### INTAKE SCREENING COMMENTS RESPONSE

Permit Number **2208-260**

Project Address 8455 SE 83<sup>RD</sup> ST.  
Mercer Island, WA 98040

Subject **Response to Building Permit Intake Screening Comments**

**A1.0a**

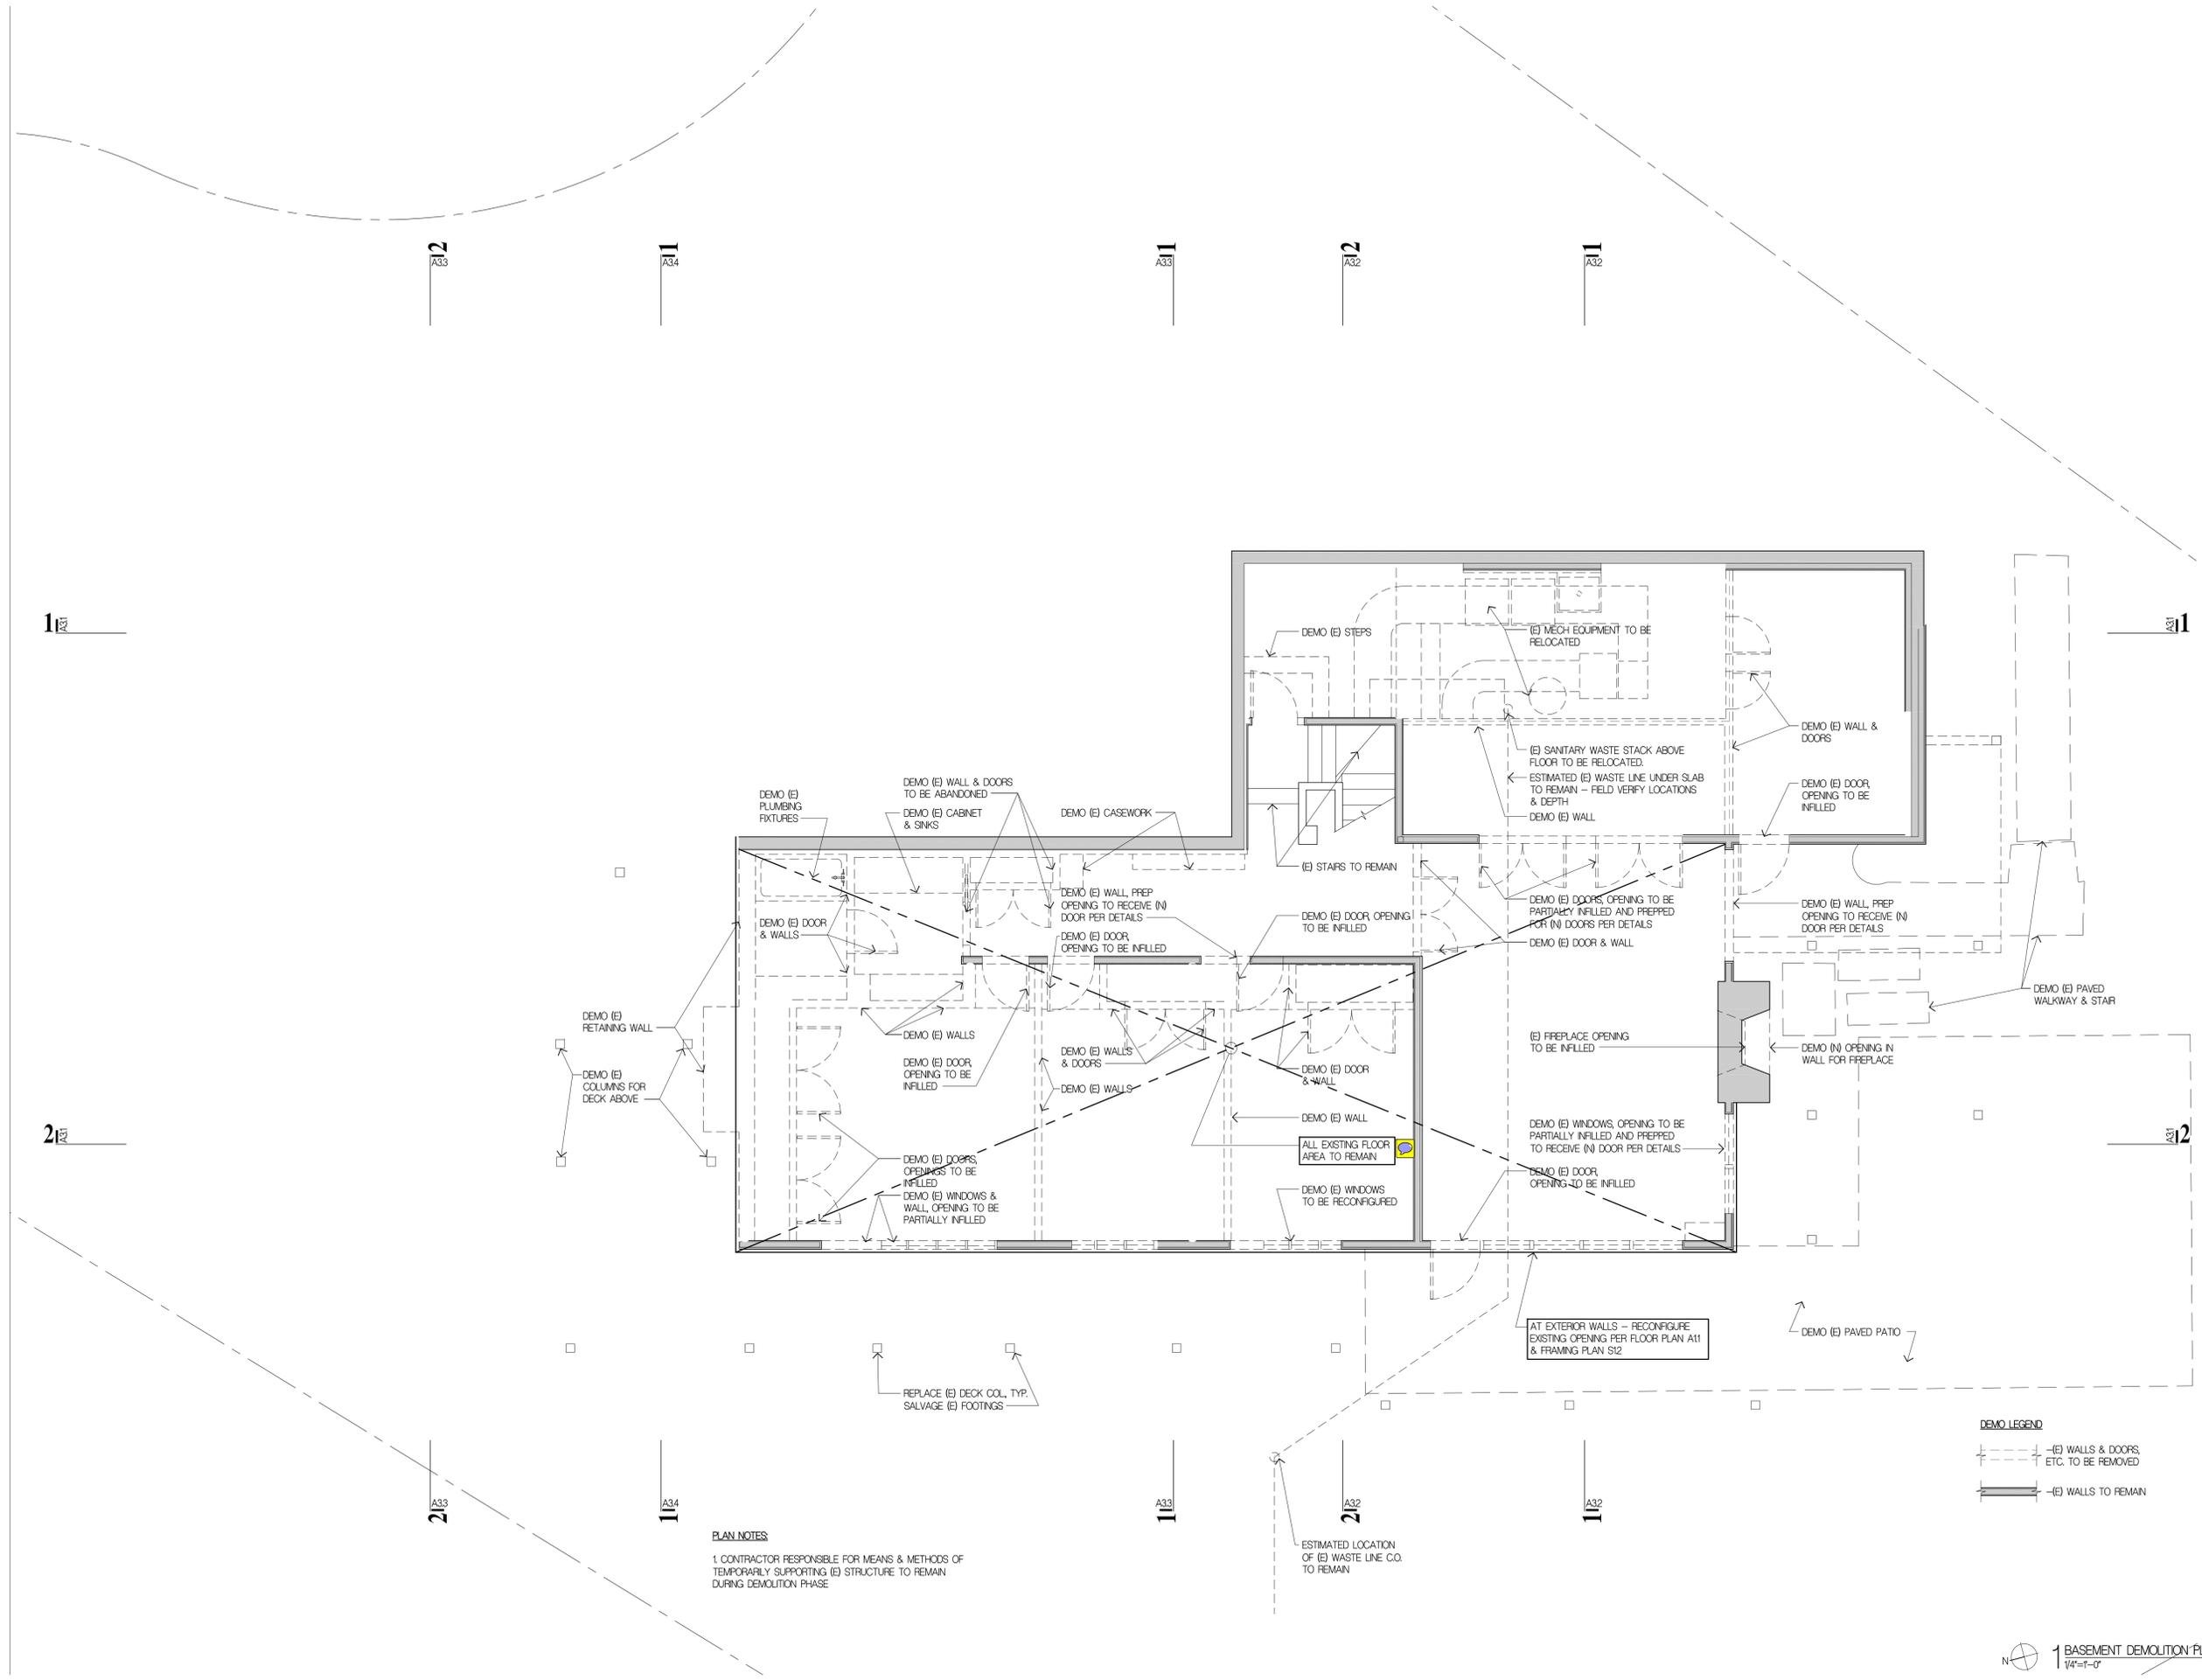
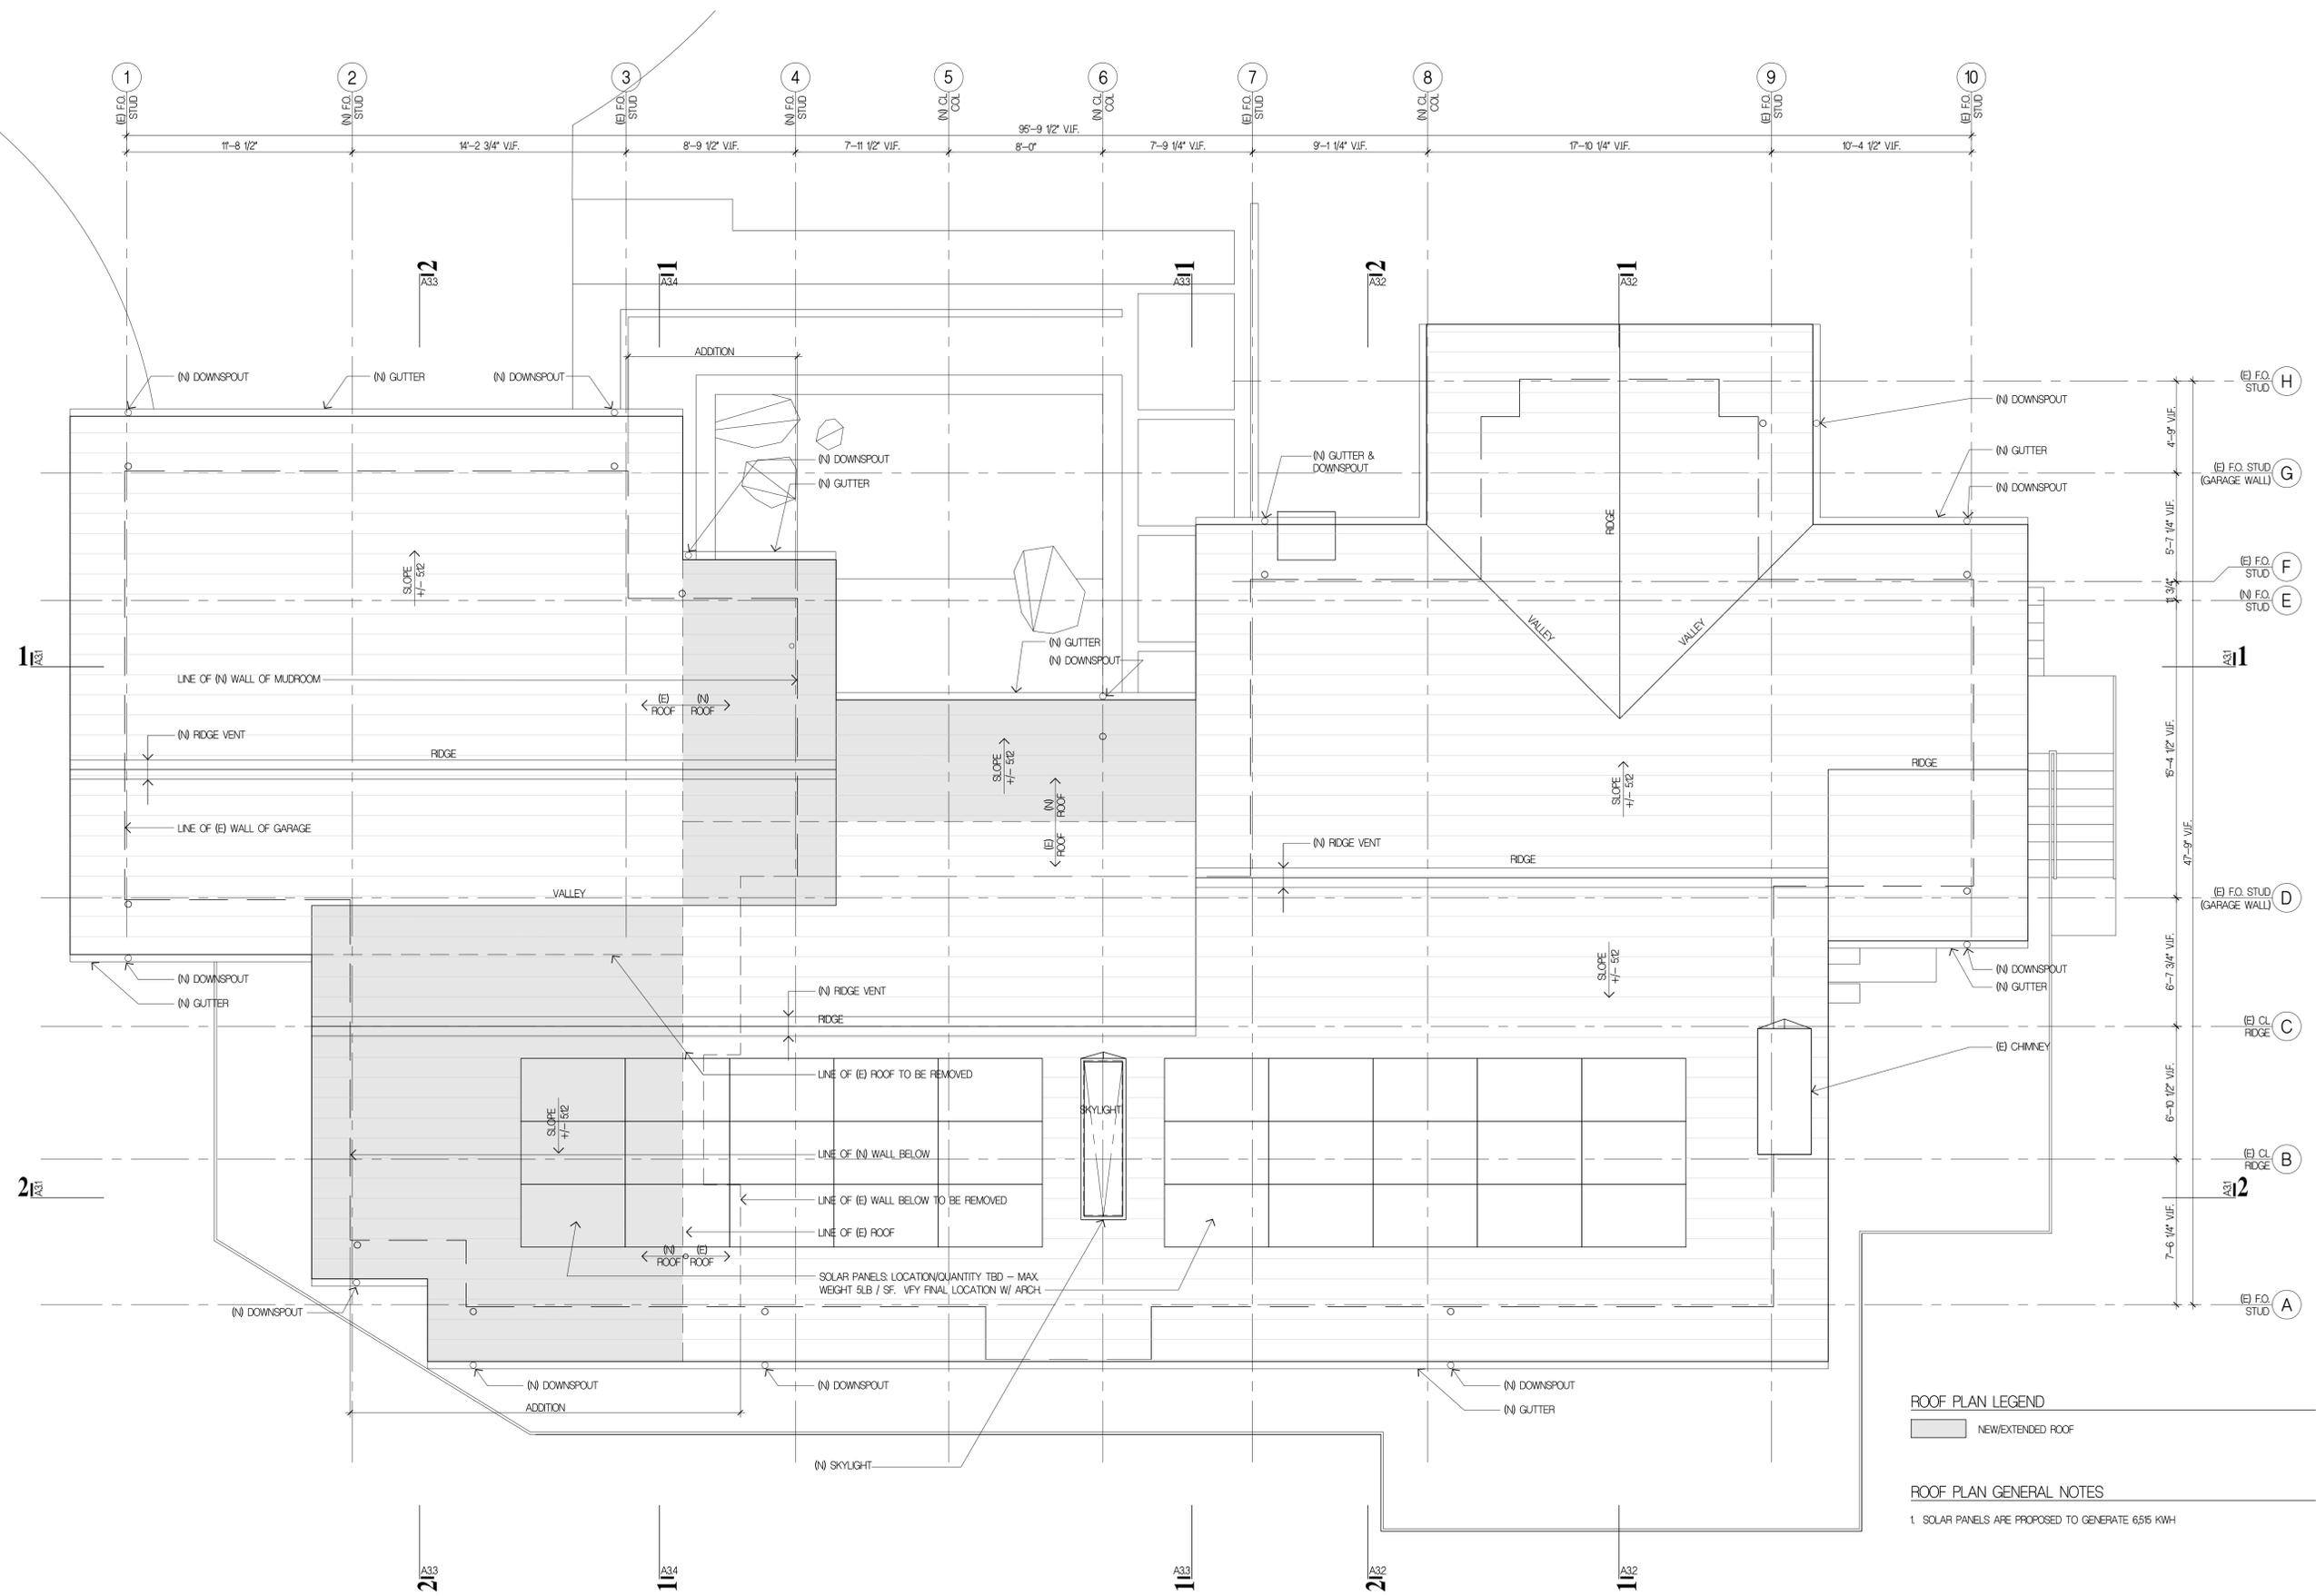
1. **Demonstrate that New plus Replaced Hard Surface is less than 2,000 sf:**  
Response: Please refer to the revised sheets – Site Diagram 2/TS-4, Demolition Floor Plans A1.0a & A1.0b, and A3.3, to clarify the scope of work showing that the proposed work involved is less than 2,000 sf of New plus Replaced Hard Surface.
